K. TROTMAN- ARCHITECTURAL SERVICES

Your Ref; FP/153/11/

PROPOSED DORMER ON EXISTING WEST ELEVATION

PROPOSED DORMER BEDROOMS
Revised plan, reduction in dormer length.

PROPOSED DORMER ON EXISTING WEST ELEVATION

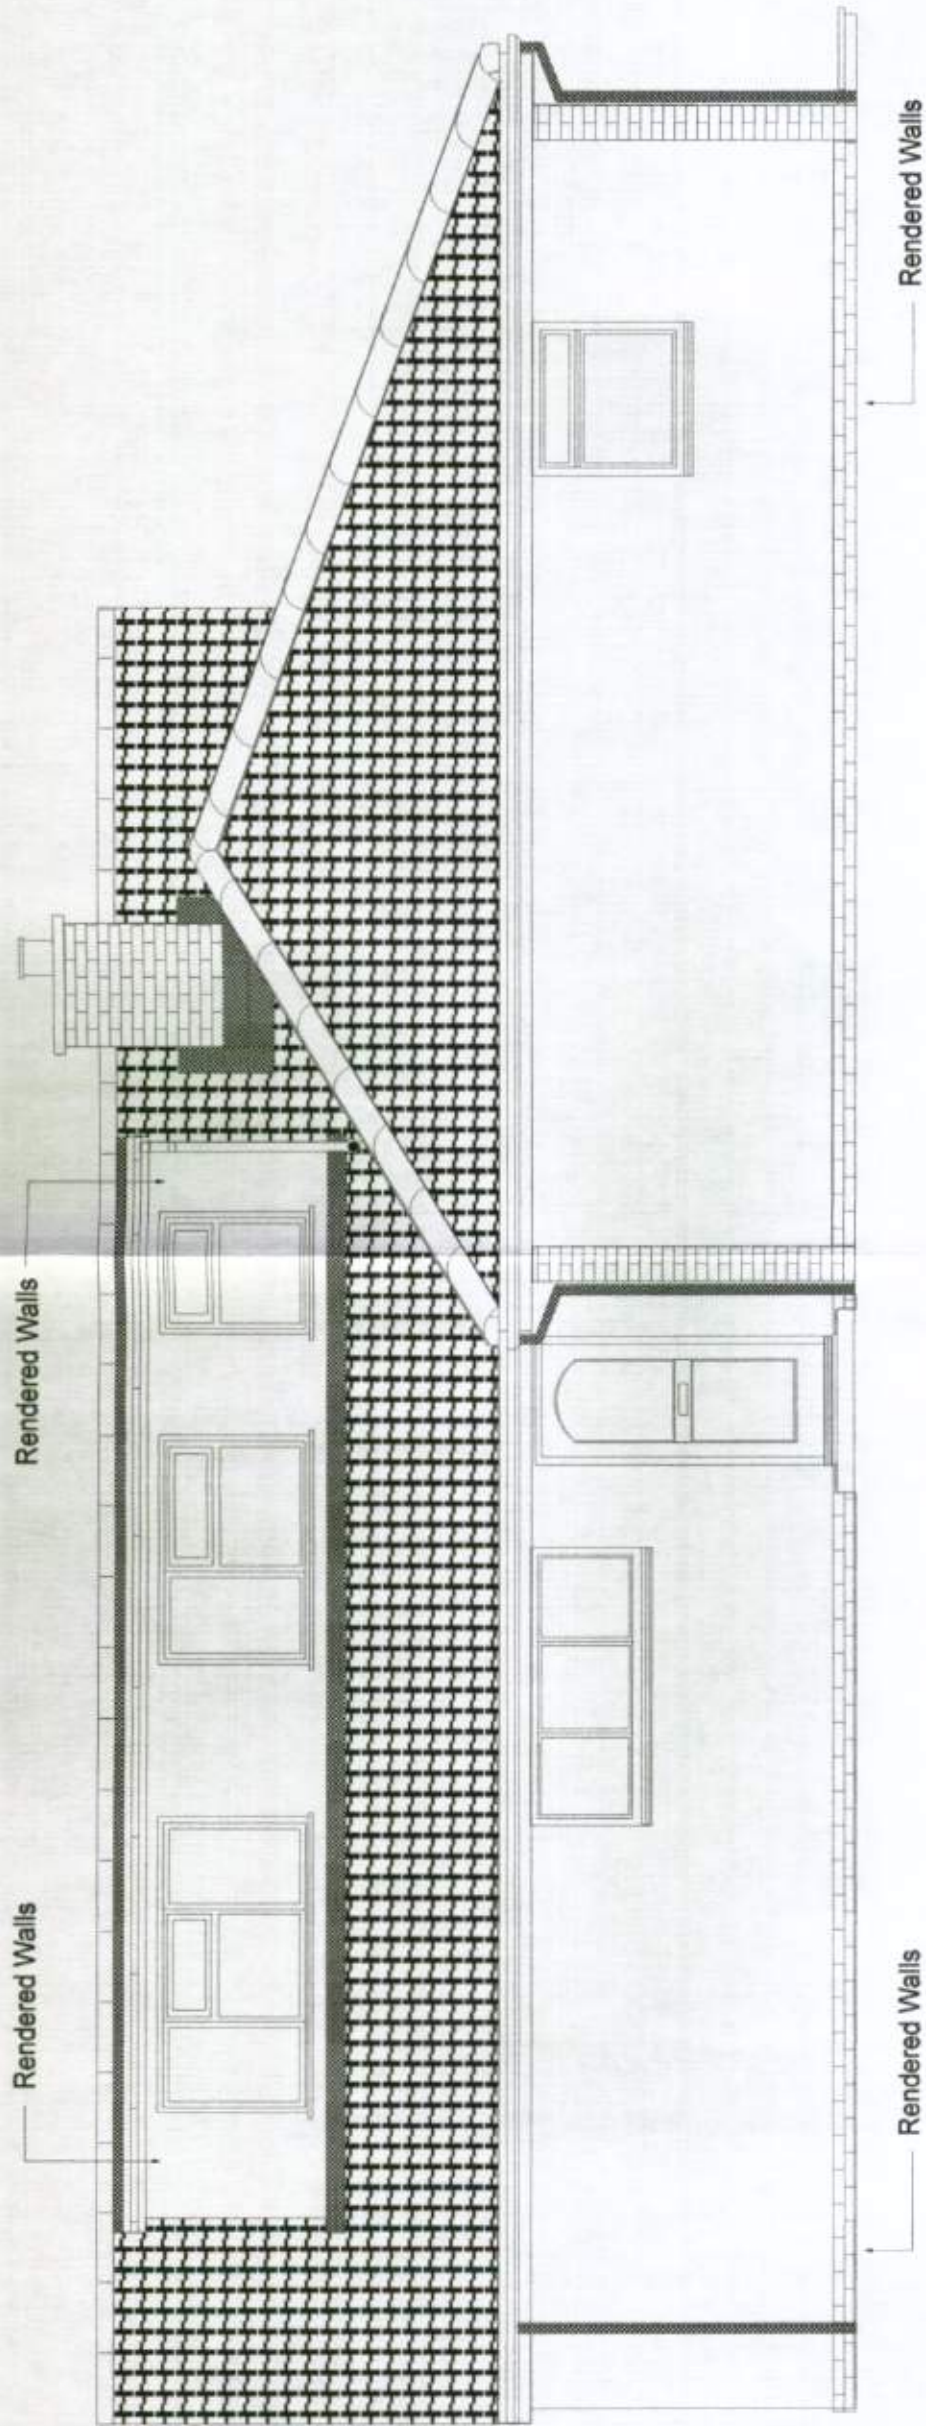
Smaller, 2 pane dormer -
set below ridge. -

Further to our communication of the 6th Sept 11, I have redrawn the West Elevation of this dormer at 64 Wroxham Way, Felpham as you requested. I have also included a revised floor plan so as you can see the reason as to why I was unable to draw two dormers, however you will see that I have reduced its length by nearly two metre's.

FLOOR AREA, STUD WALLS & WINDOW POSITIONS

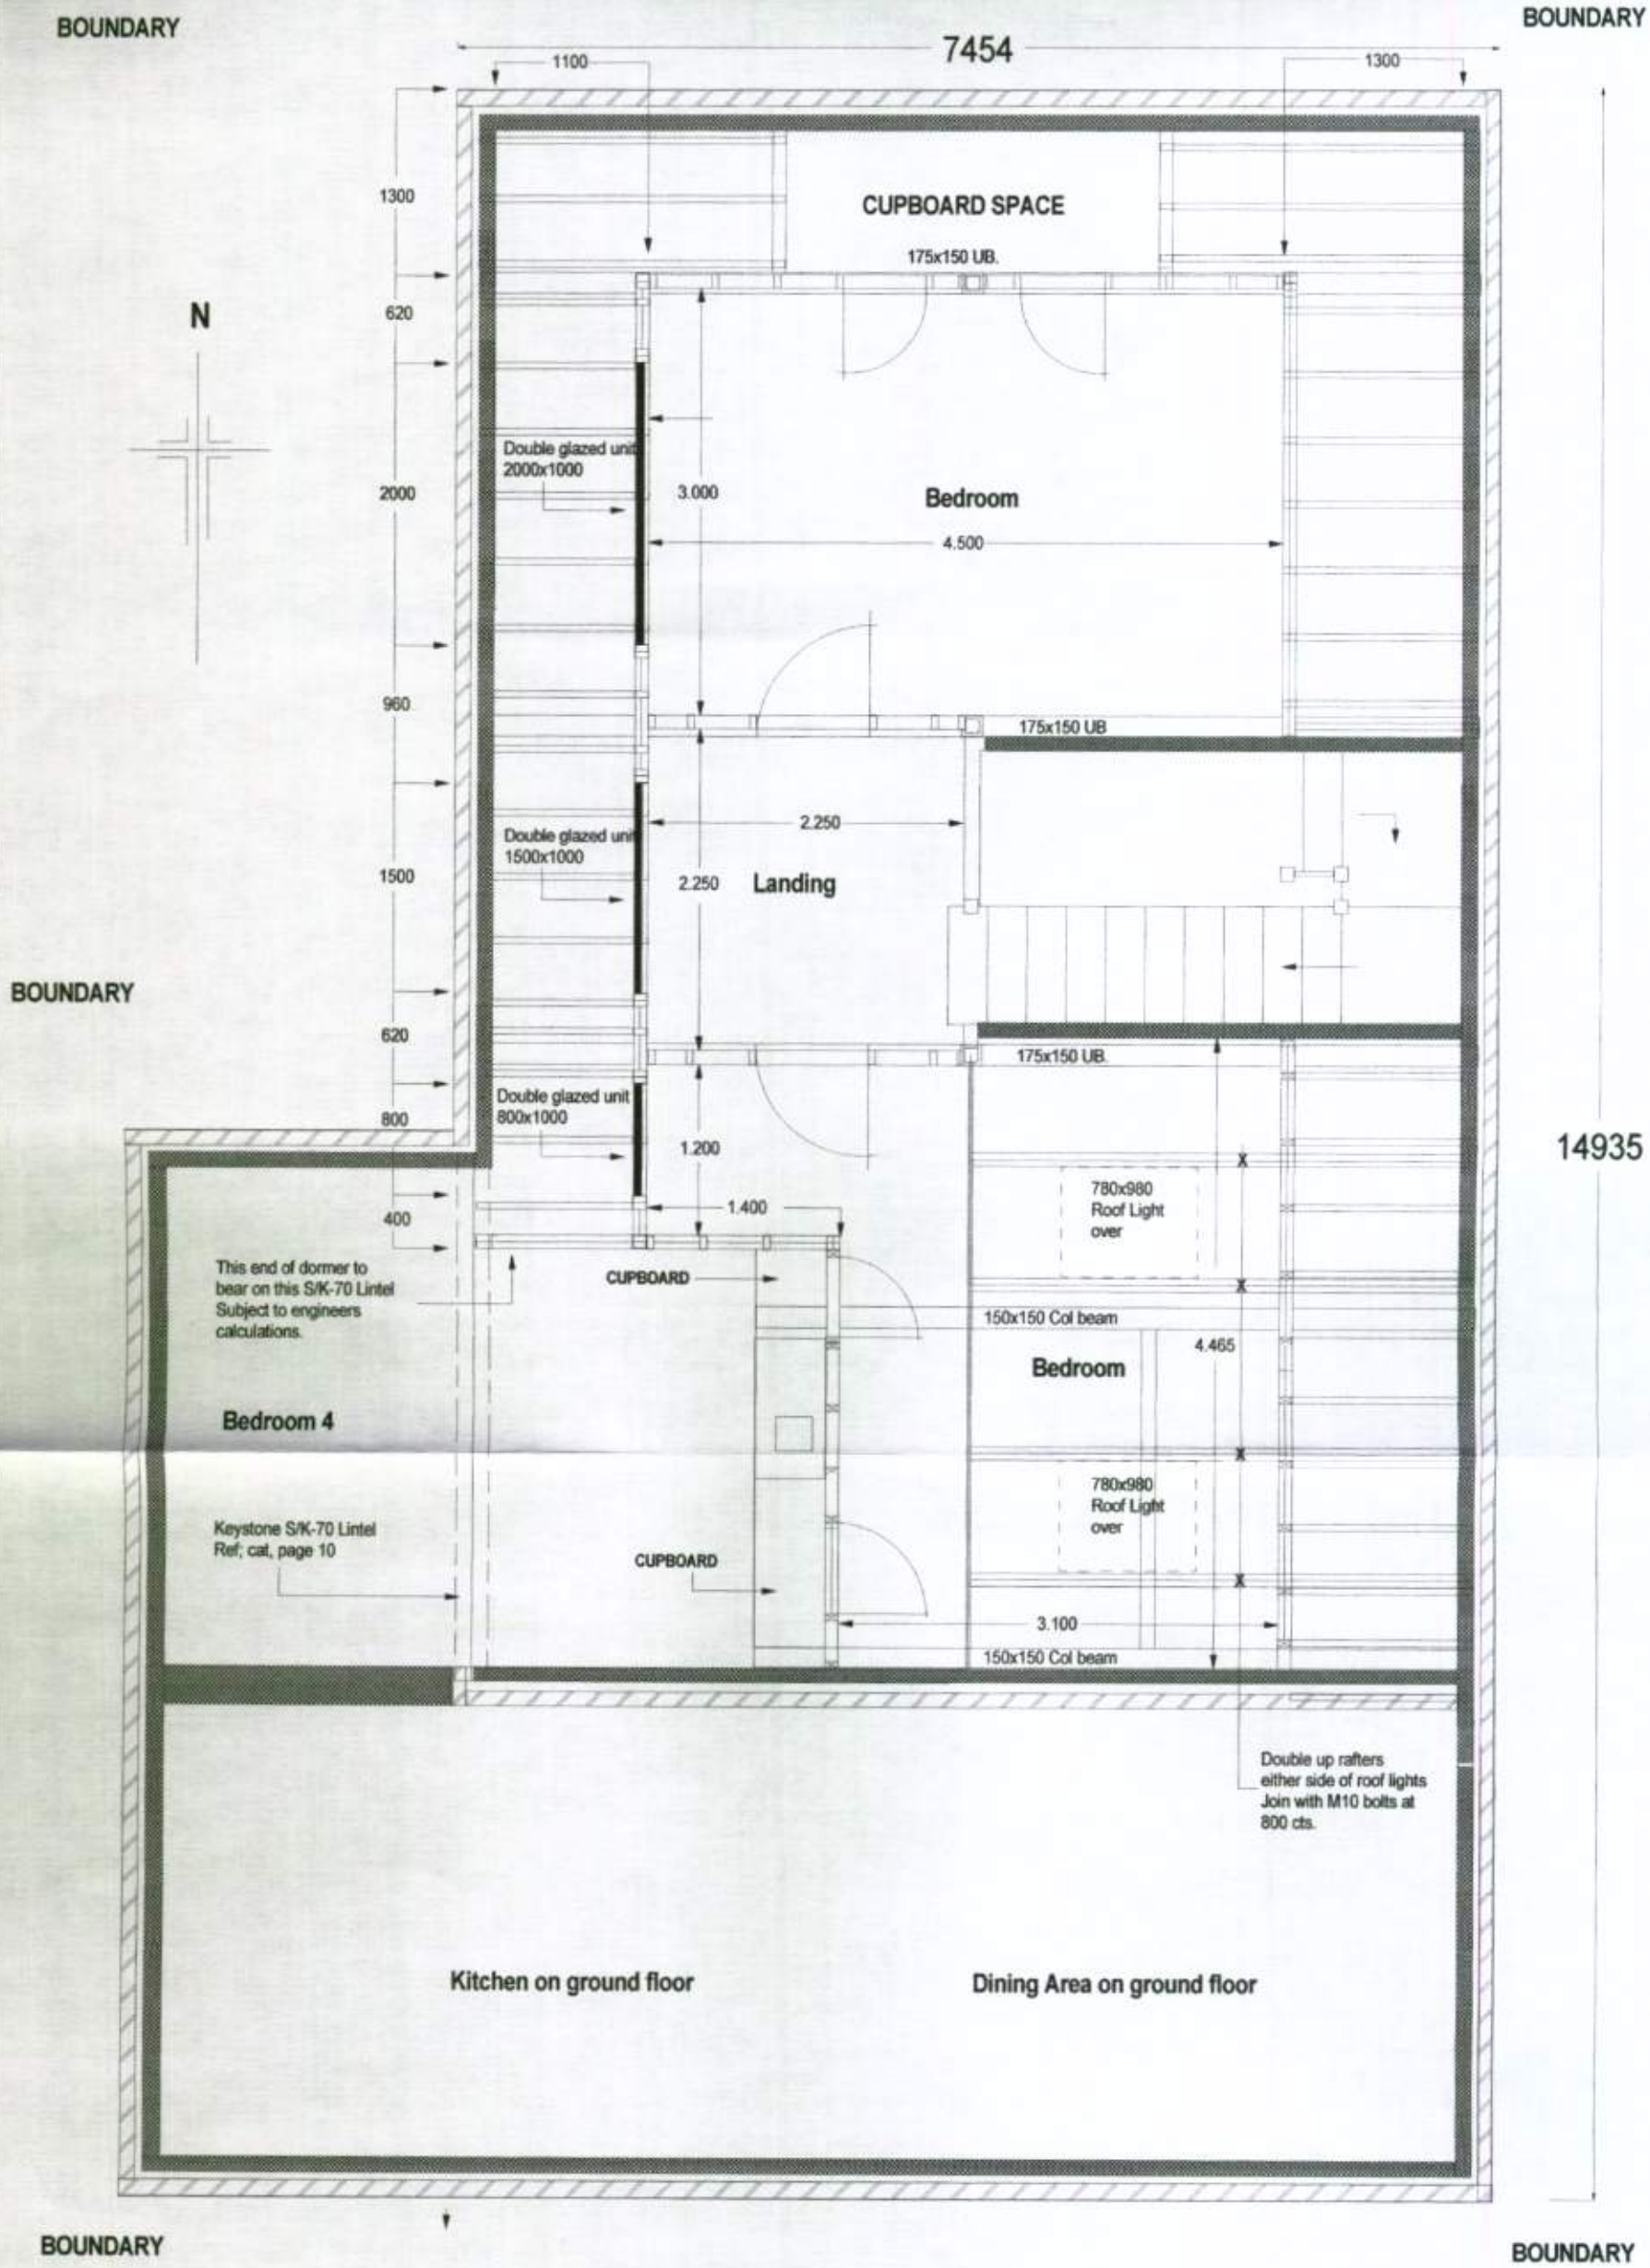
The position of the staircase or should I say the room that it is sited in has dictated the design of the roof at the point at the entry to the landing space. Unfortunately this is the only position that the stairs can go. I look forward to your comments.
